Please ask for: Mrs D Johnson
Email: daun.johnson@arun.gov.uk
Telephone: 01903 737762
Our Ref: BN/68/22/PL
Your Ref:
Date: 20th May 2022

Application for Planning Permission

Development: Erection of 4 x 4 bedroom houses. This application is a Departure from the Development Plan and is in CIL Zone 3 and is CIL Liable as new dwellings.
Location: Land Adjacent To Wayside Eastergate Lane Eastergate PO20 3SJ

Appendix A Proposed Site Plan

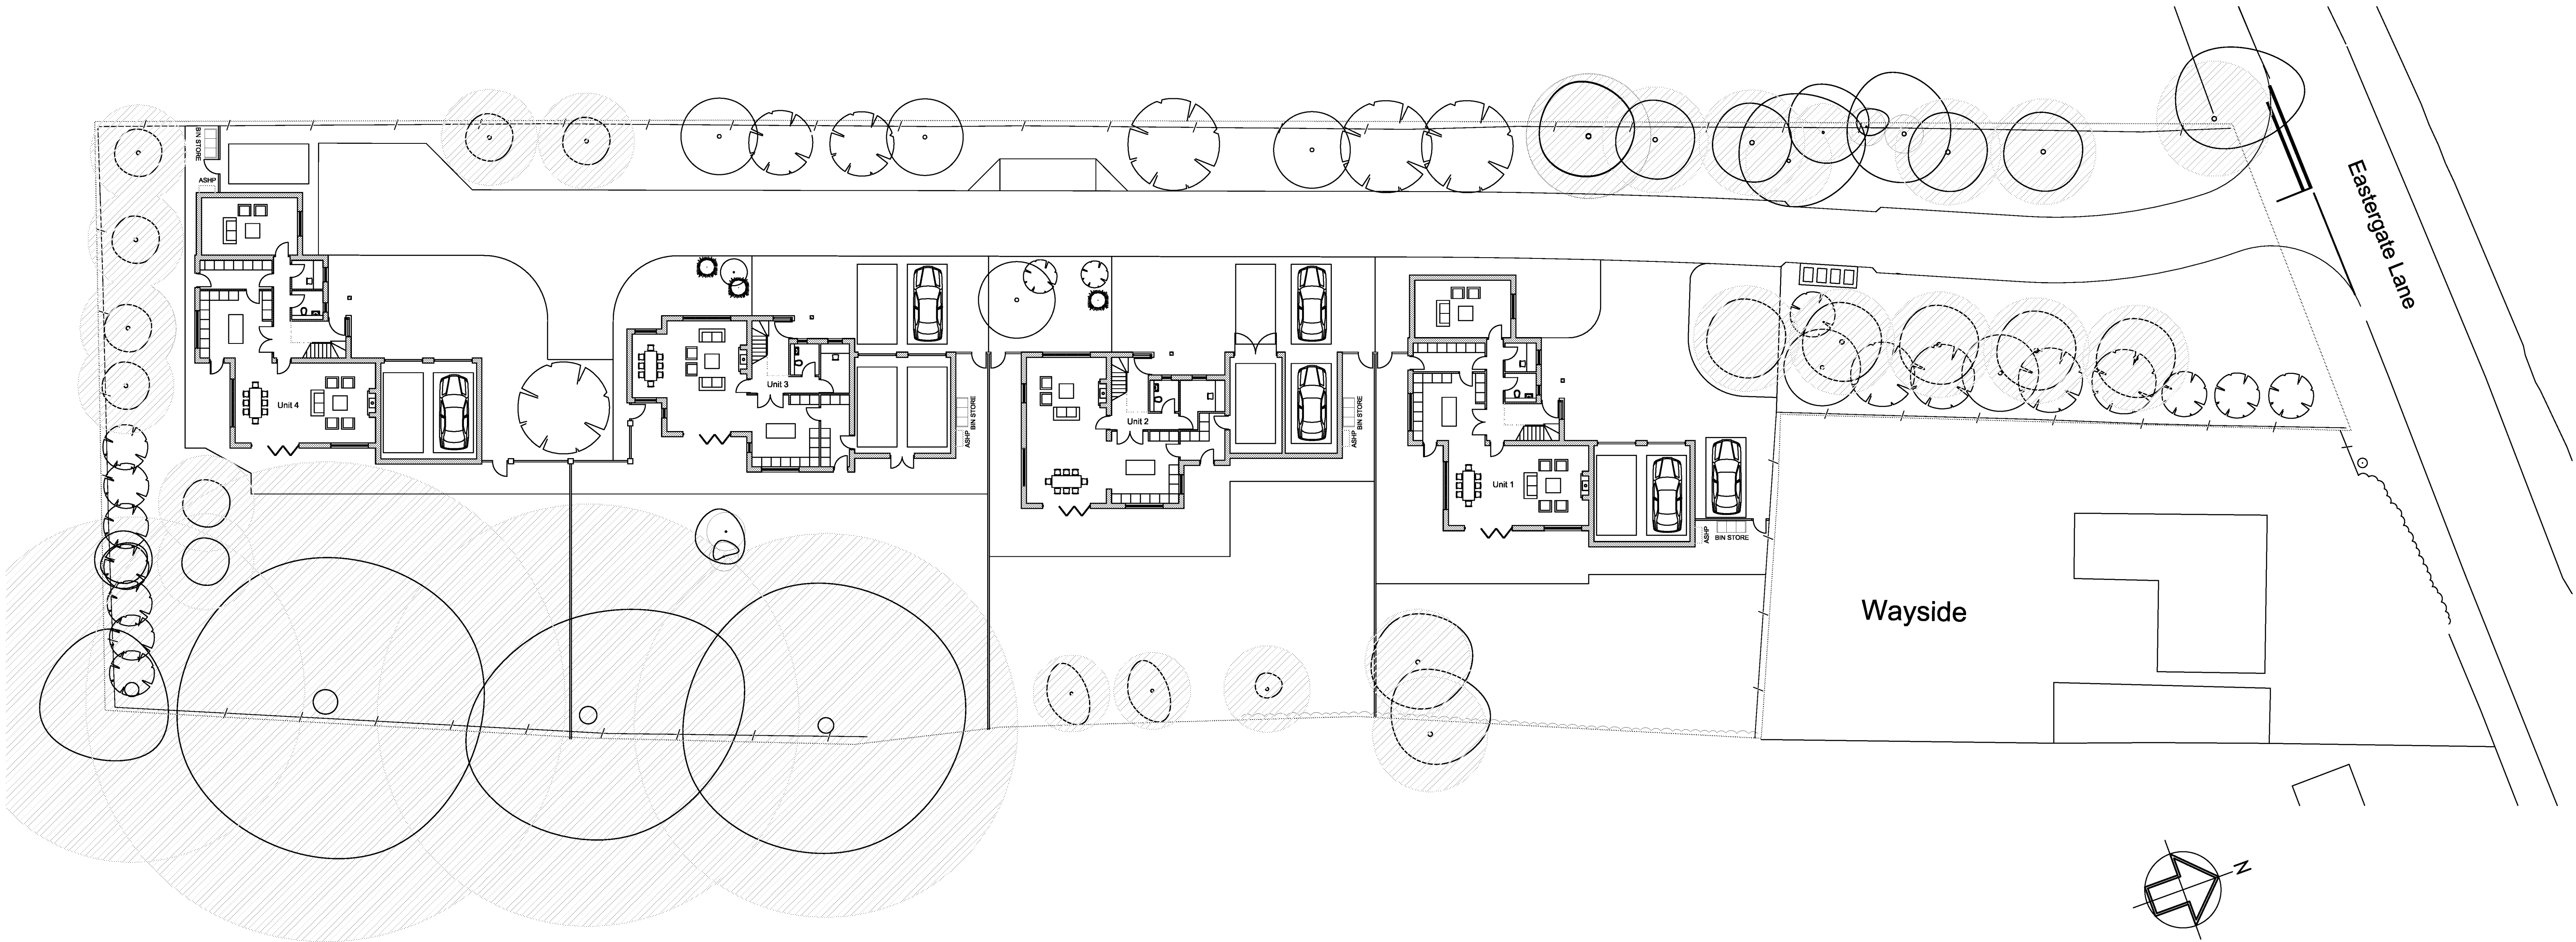
On the proposed site layout plan, please provide dimensions from the proposals to the site boundaries.
